**Southern
Water**

Our ref
PLAN-034709

Proposal: Approval of reserved matters for 3785sqm of light industrial floorspace (Class B1 (b)/(c)) following the grant of WA/22/15/OUT.

Site: BN/57/19/RES: - Land East of Fontwell Avenue, Fontwell Avenue, Fontwell, BN18 0SB.

Client Rural Associates Project Title and Location GTR Factory Arundel Road, Fontwell, West Sussex	Drawing Title Detailed Planting Plan Ornamental Planting
Scale 1:100@A1	Drawn EZ
Approved DW	Date 30.01.20
Drawing No LLD1773-LAN-DWG-201	Revision 02

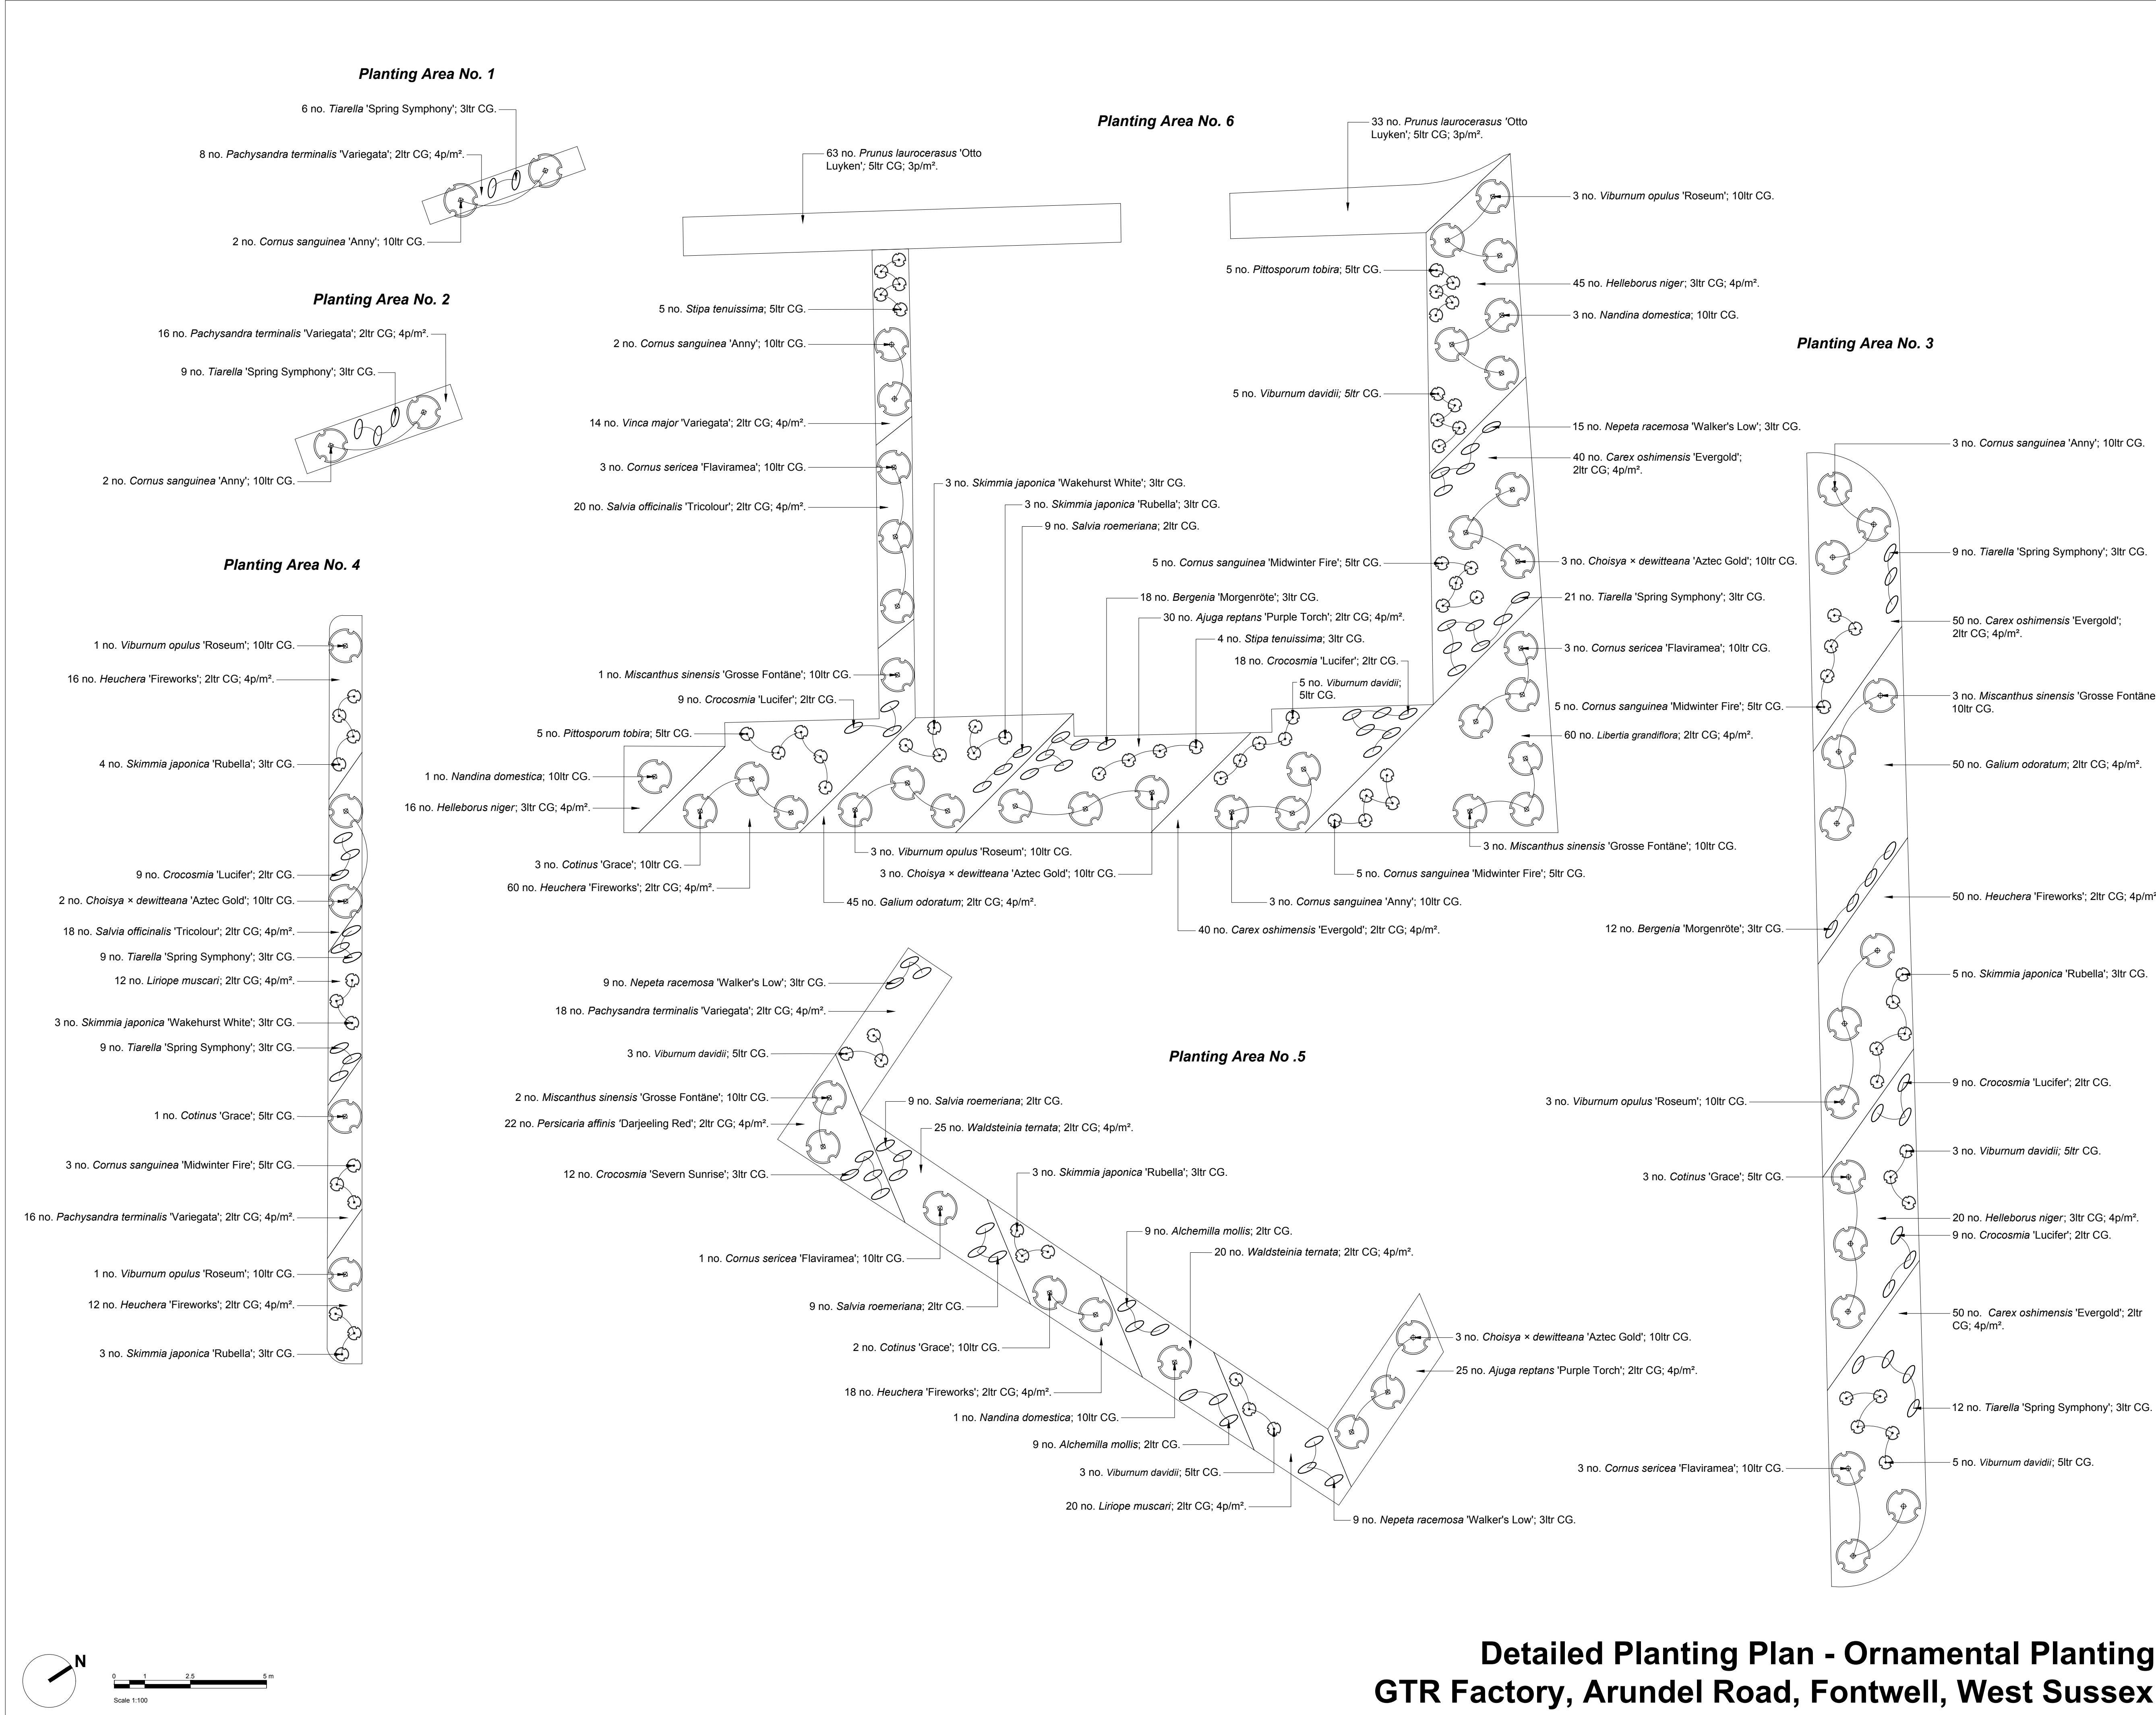
The submitted plans shows proposed tree planting within standoff distance from public drainage apparatus.

We have restrictions on the proposed tree planting adjacent to Southern Water sewers, rising mains or water mains and any such proposed assets in the vicinity of existing planting. Reference should be made to Southern Water's publication "A Guide to Tree Planting near water Mains and Sewers" (southernwater.co.uk/media/1642/ds-tree-planting-guide.pdf) and the Sewerage Sector Guidance (water.org.uk/sewerage-sector-guidance-approved-documents/) with regards to any landscaping proposals and our restrictions and maintenance of tree planting adjacent to sewers, rising mains and water mains.
